Application Ref:	3/2018/0913	 Ribble Valley Borough Council <small>www.ribblevalley.gov.uk</small>
Date Inspected:	26/11/2018	
Officer:	AB	
DELEGATED ITEM FILE REPORT:		APPROVAL

Development Description:	Installation of a backup electrical generation hub together with security fencing, access, substations, gas kiosk and associated plant and equipment.
Site Address/Location:	Land off Clitheroe Road adj Shaw House Farm BB7 9AD

## SHAWHOUSE, WHALLEY - SITE LAYOUT

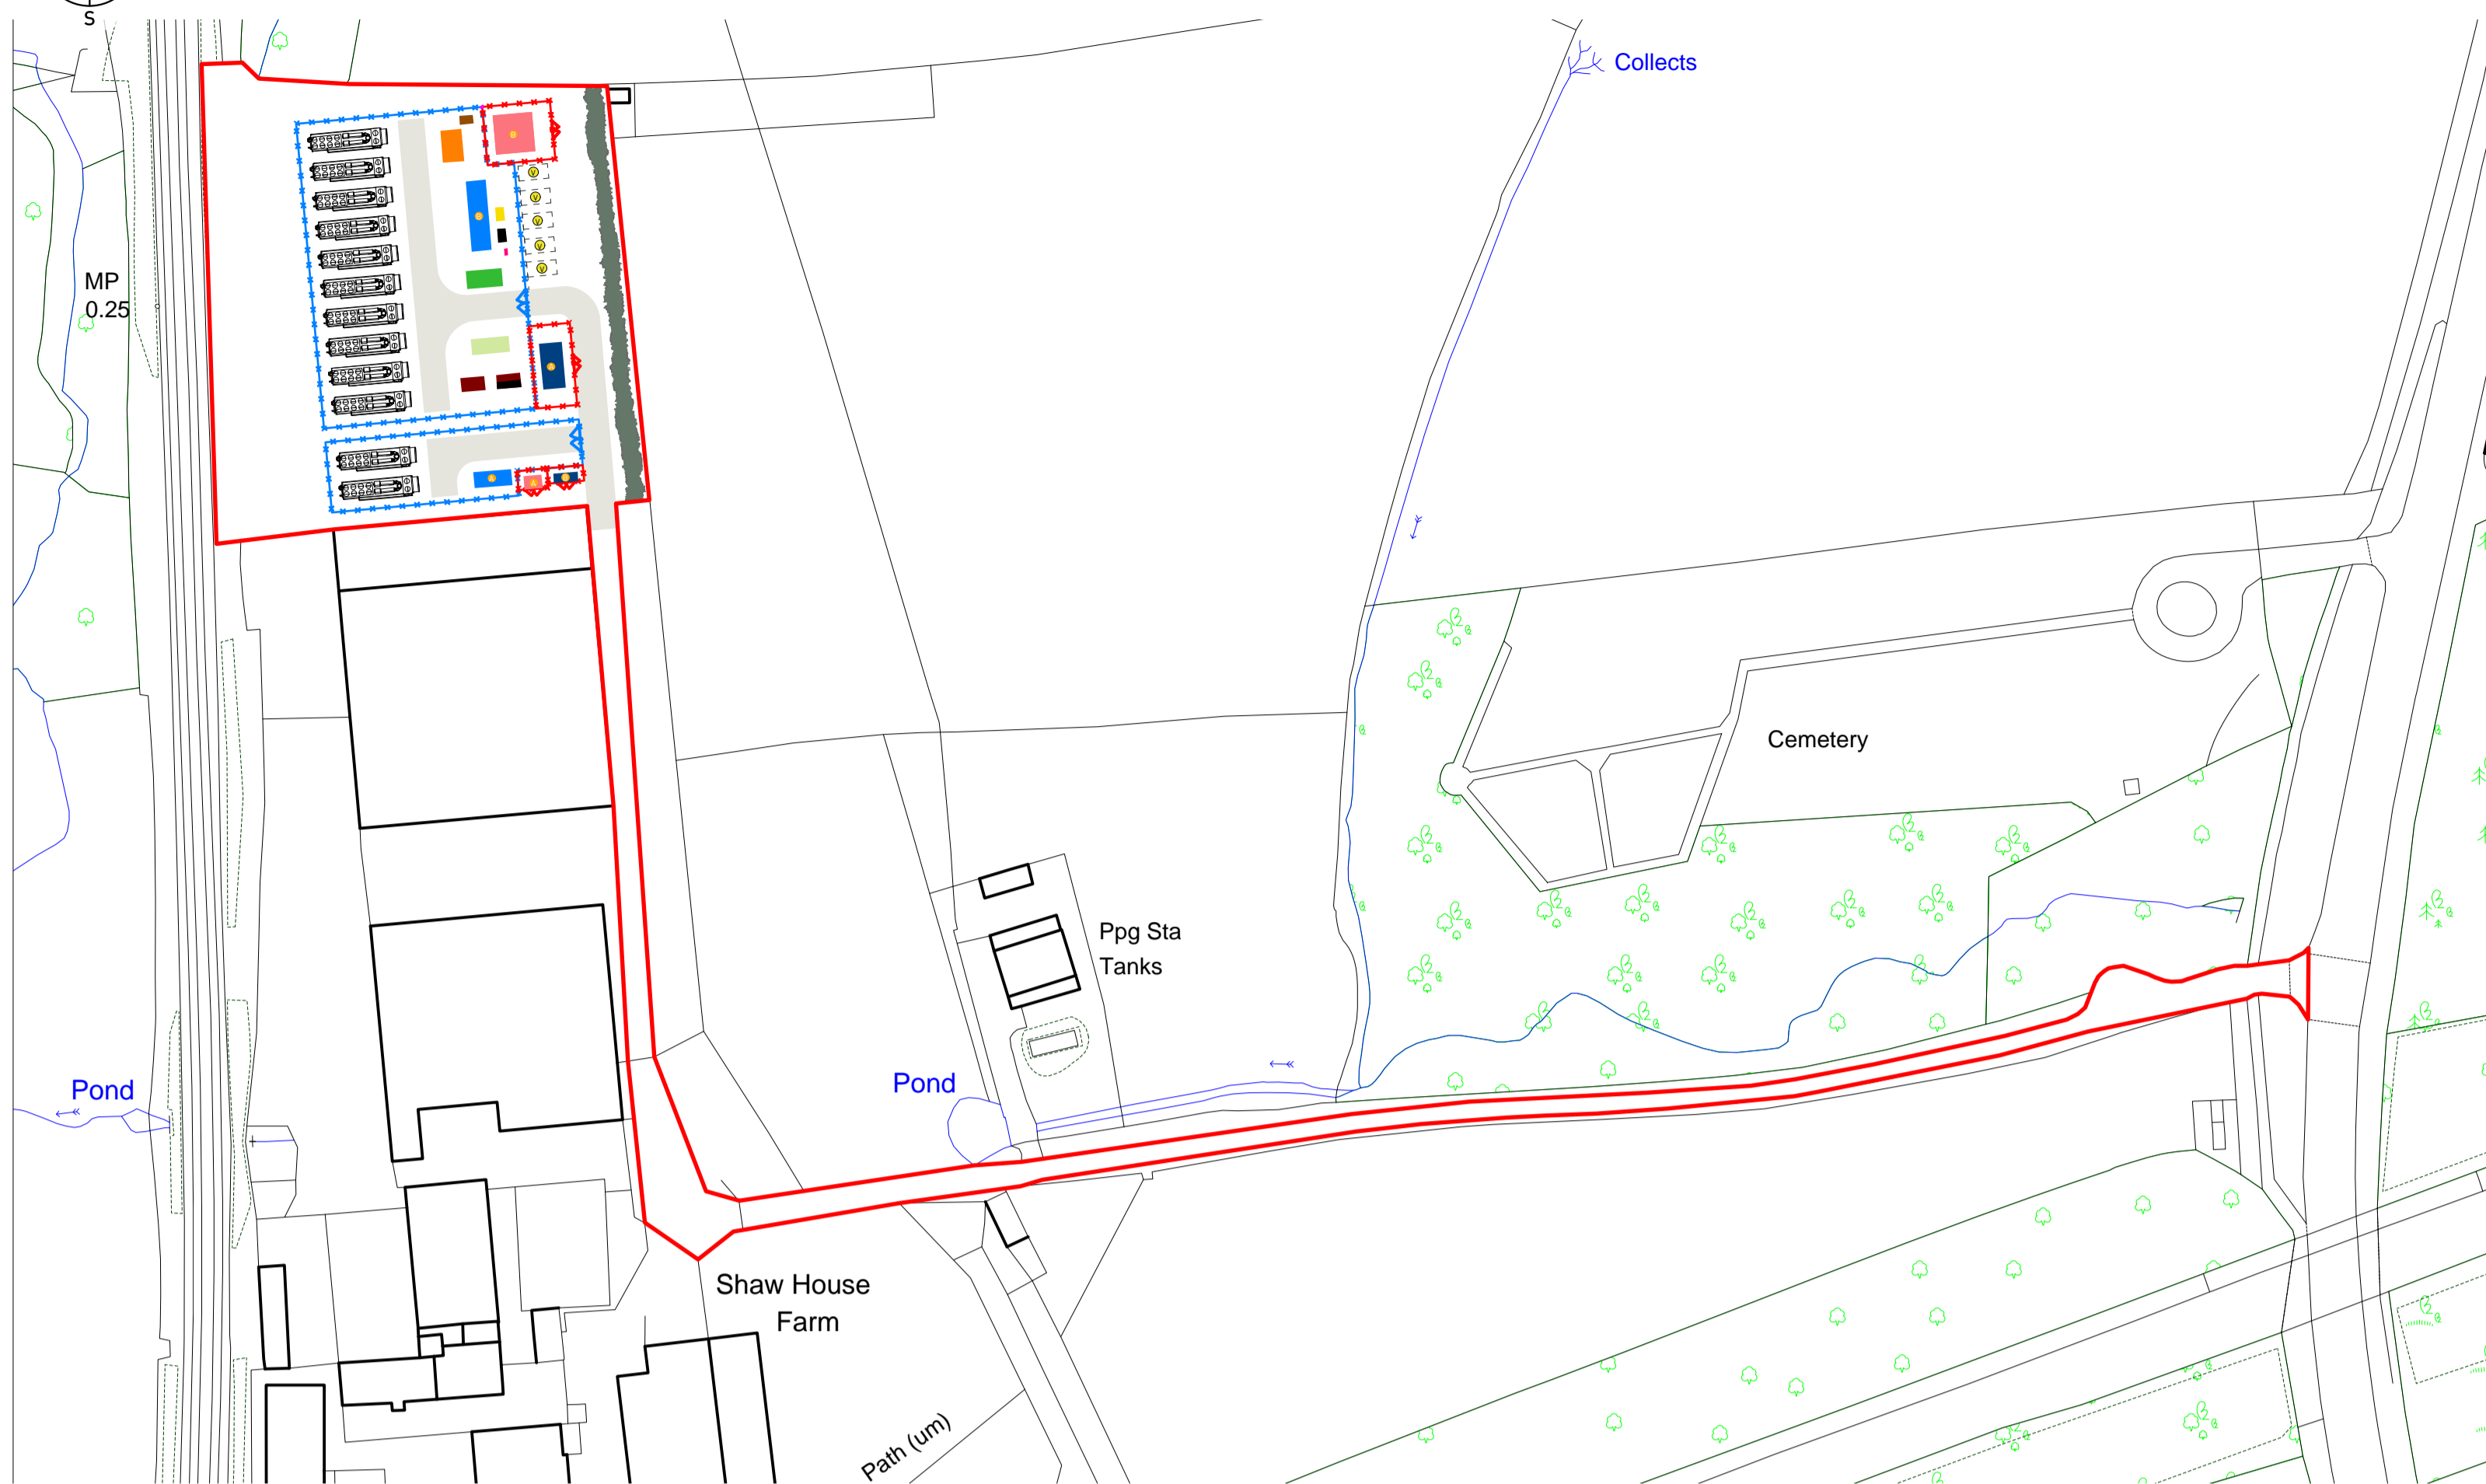
- Can Network Rail have sight of the significant findings from the site fire and DSEAR risk assessment documents.
- We require sight of an accurate depot layout plan showing the locations of any gas storage units, generators, fuel stores etc.

- Will the site be manned 24/7 by security personnel?
- Details of proposed transformer/substation locations (if applicable) to be submitted to Network Rail for acceptance due to risk of electro-magnetic interference with Signalling equipment.

The comments provided by Network Rail have been noted and the application considers that the points raised can be satisfied through the imposition of appropriately worded planning conditions.
